Application by Snowdonia Pumped Hydro Limited for an Order Granting Development Consent for the Glyn Rhonwy Pumped Storage Scheme

Request for further information schedule

Issued on 20 July 2016

APPENDIX B: INCIDENT PROCEDURE FLOWCHART

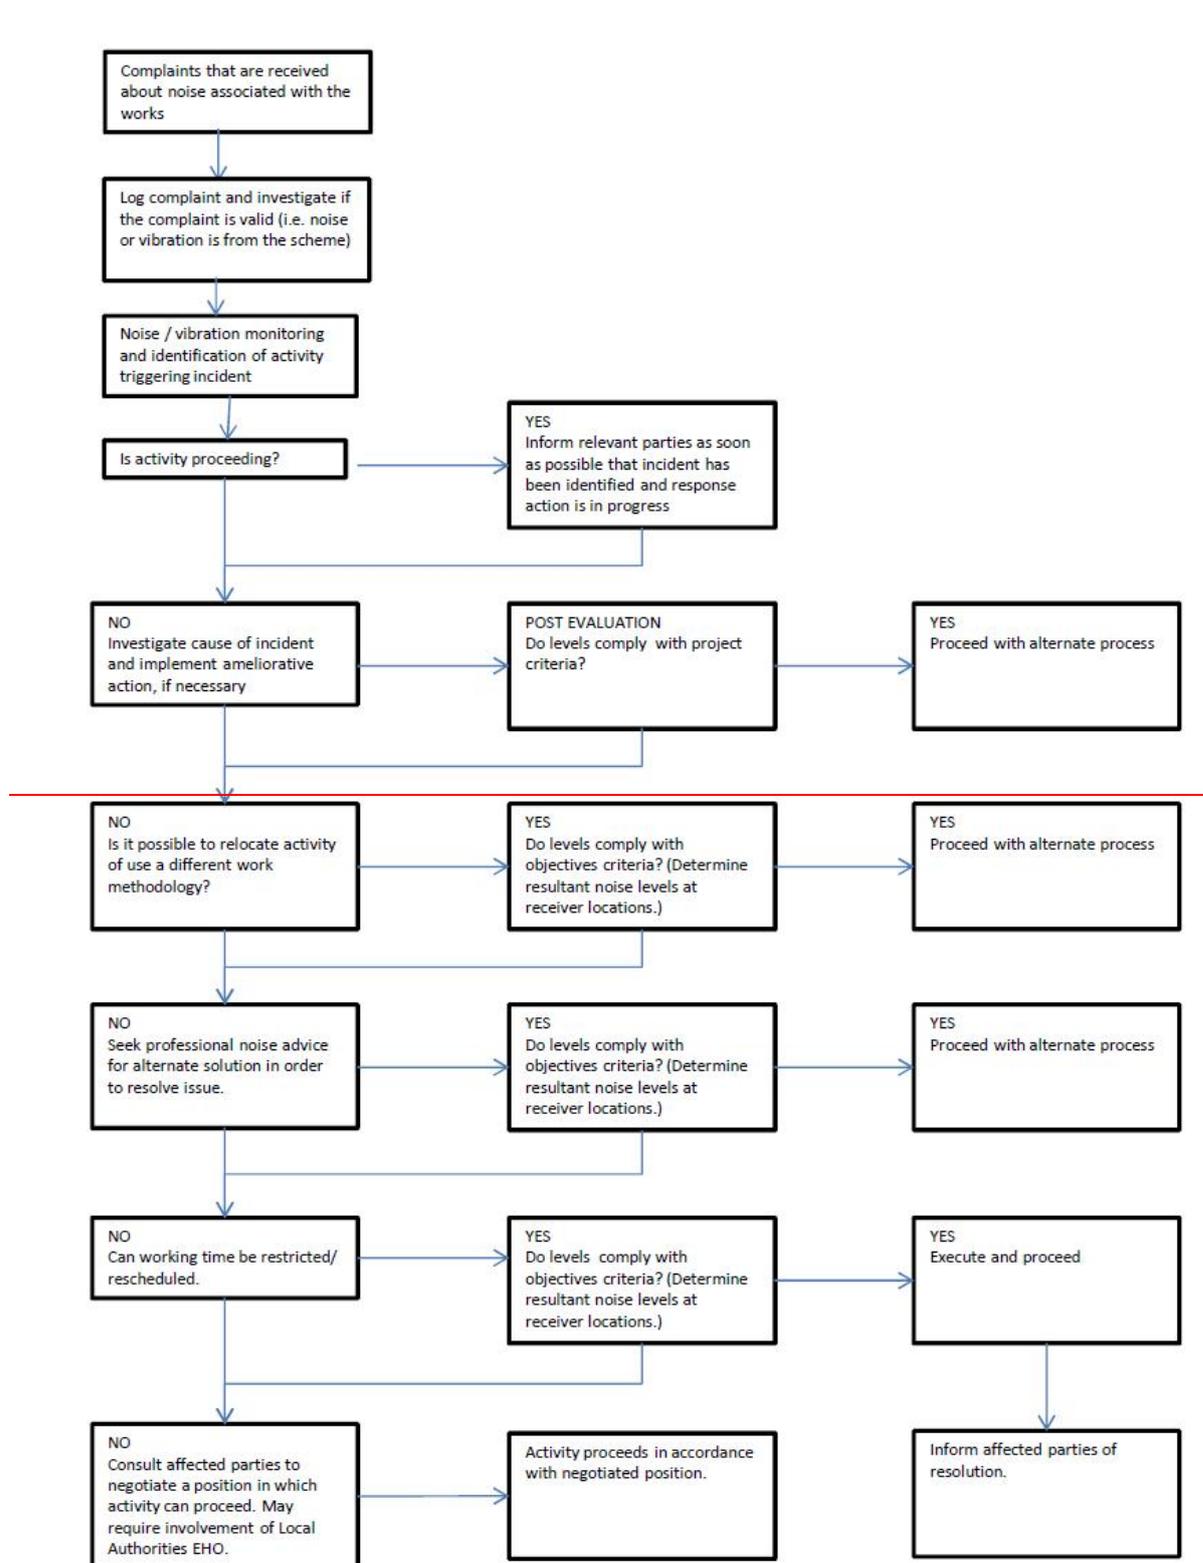
6.25.	Applicant	a) Please update the incident procedure flowchart in the outline CNMP [REP5-011, appendix B] and outline Operational Noise Management Plan (ONMP) [REP5-012, appendix B] to clarify relevant planning authority and local resident notification and involvement. b) Please could GC comment?
